WEST SUSSEX COUNTY COUNCIL CONSULTATION

TO:	Arun District Council FAO: Stuart Corbey
FROM:	WSCC - Highways Authority
DATE:	13 May 2019
LOCATION:	Alloways, 33 Shelley Road, Bognor Regis, PO21 2SN
SUBJECT:	BR/76/19/PL Conversion of existing house into 2 No. 3 bed semi detached properties.
DATE OF SITE VISIT:	09/05/2019
RECOMMENDATION:	Advice
S106 CONTRIBUTION TOTAL:	£N/A

Proposed Conversion Proposed Plans Planning
Date March 2019
Scale 1:50

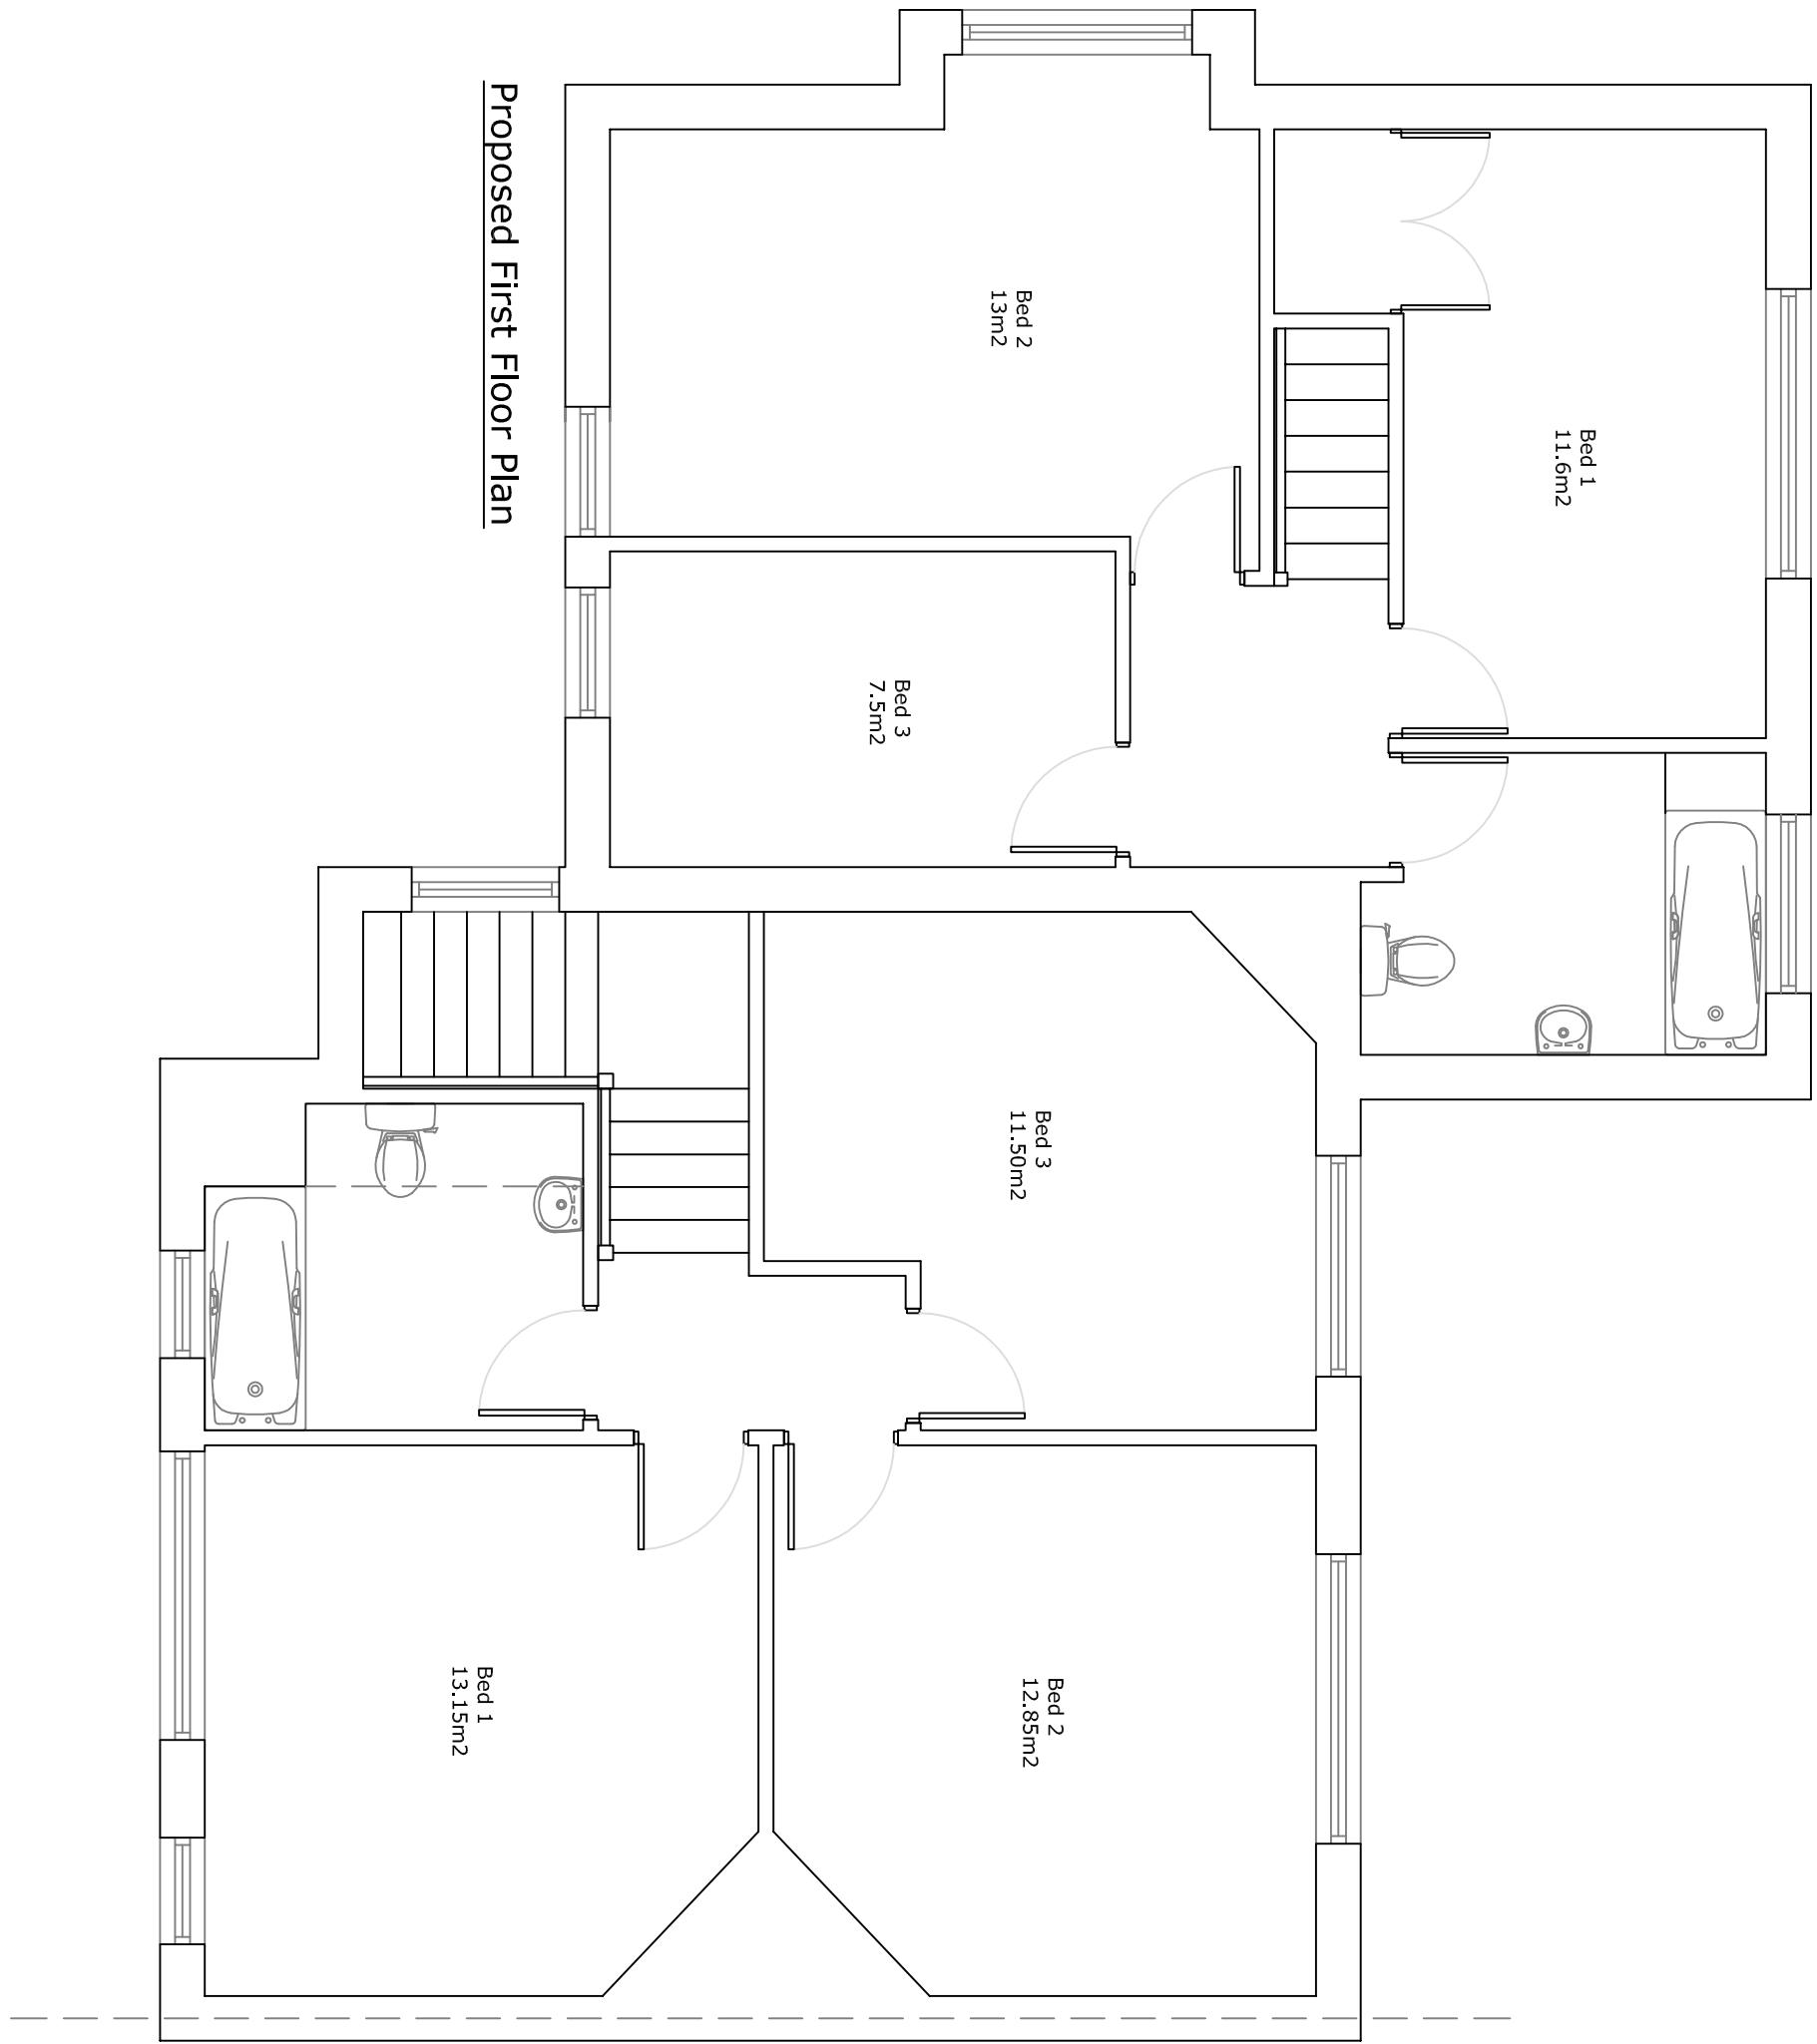
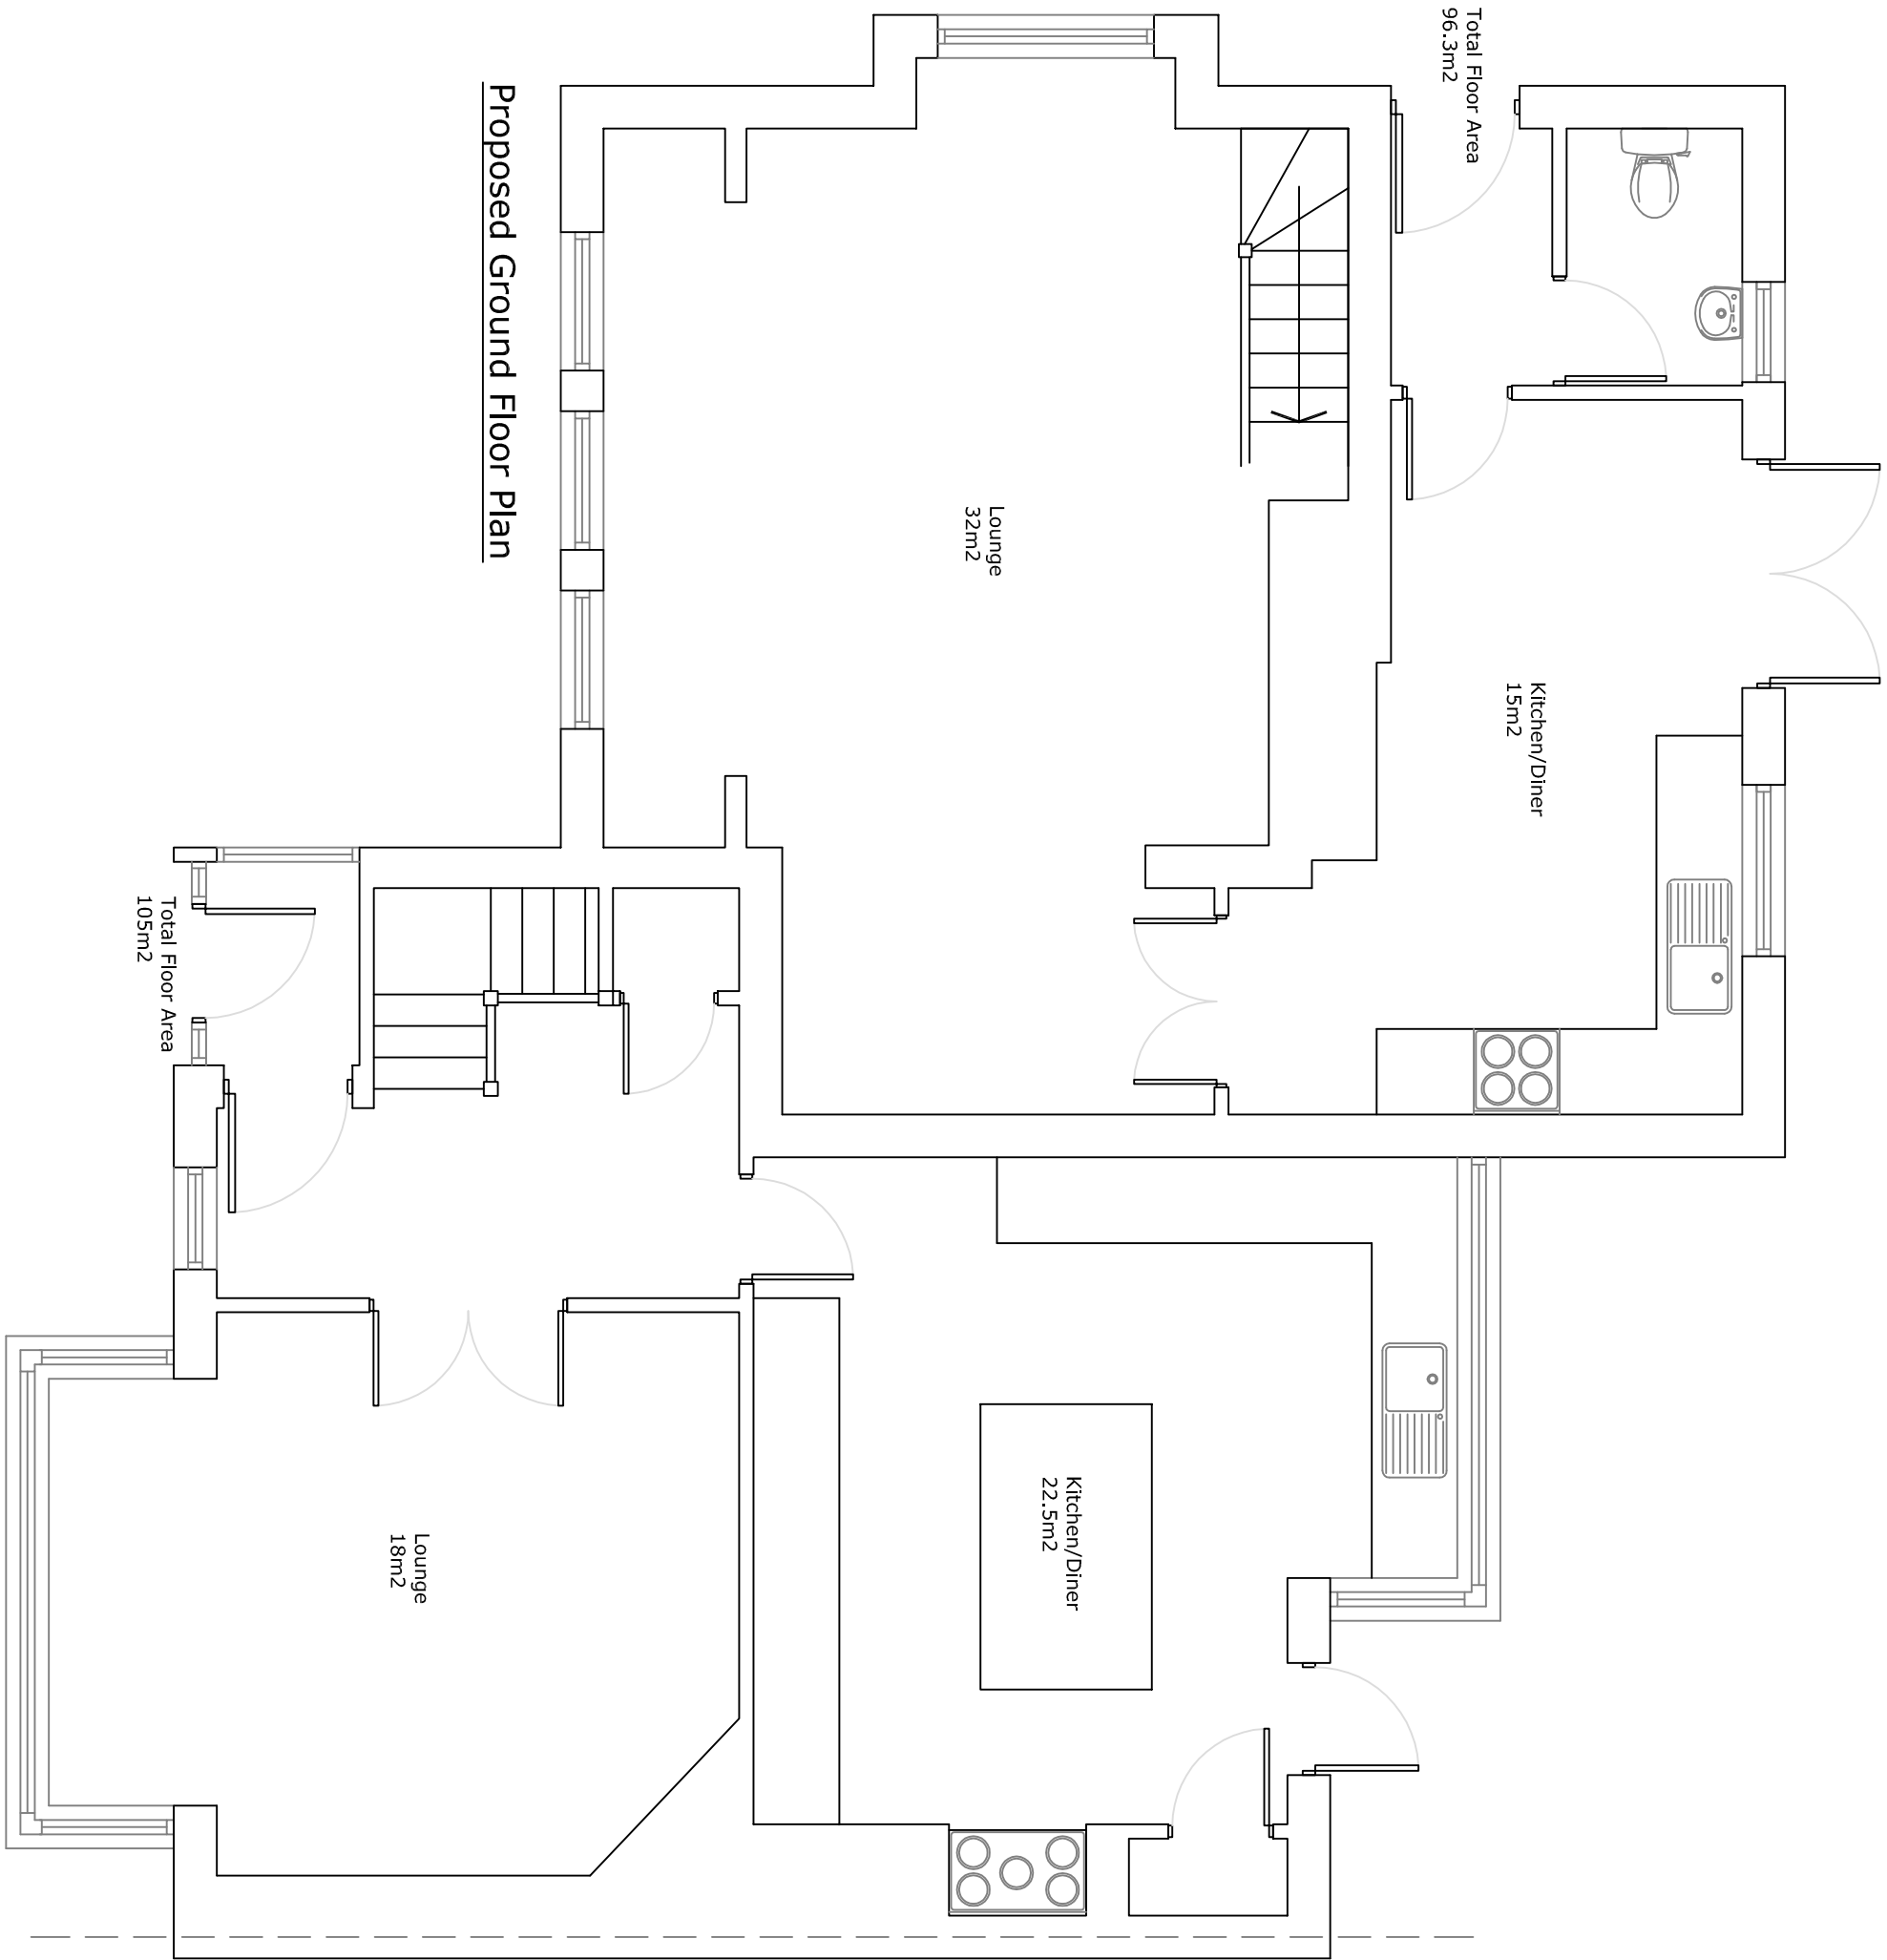
It was confirmed by site visit that the property access currently lacks a dropped kerb. Therefore this application would require a vehicle crossover (VCO) licence and must be constructed to a specification agreed with the Local Area Engineer. For a VCO to be approved, the property frontage must be at least 4.8 metres between the back edge of the pavement and the front of the property building. Given that part of the property frontage does not meet this minimum distance, a licence for the proposed VCO is unlikely to be granted for this application. It is advised that the plans are revised to meet minimum VCO criteria.

The amended plans has an alternate parking layout, with 3 bays in front of the eastern property and 1 bay parallel to the highway to the front of the western property. Turning on-site will still not be achievable, so vehicles may have to exit the site in a reverse gear.
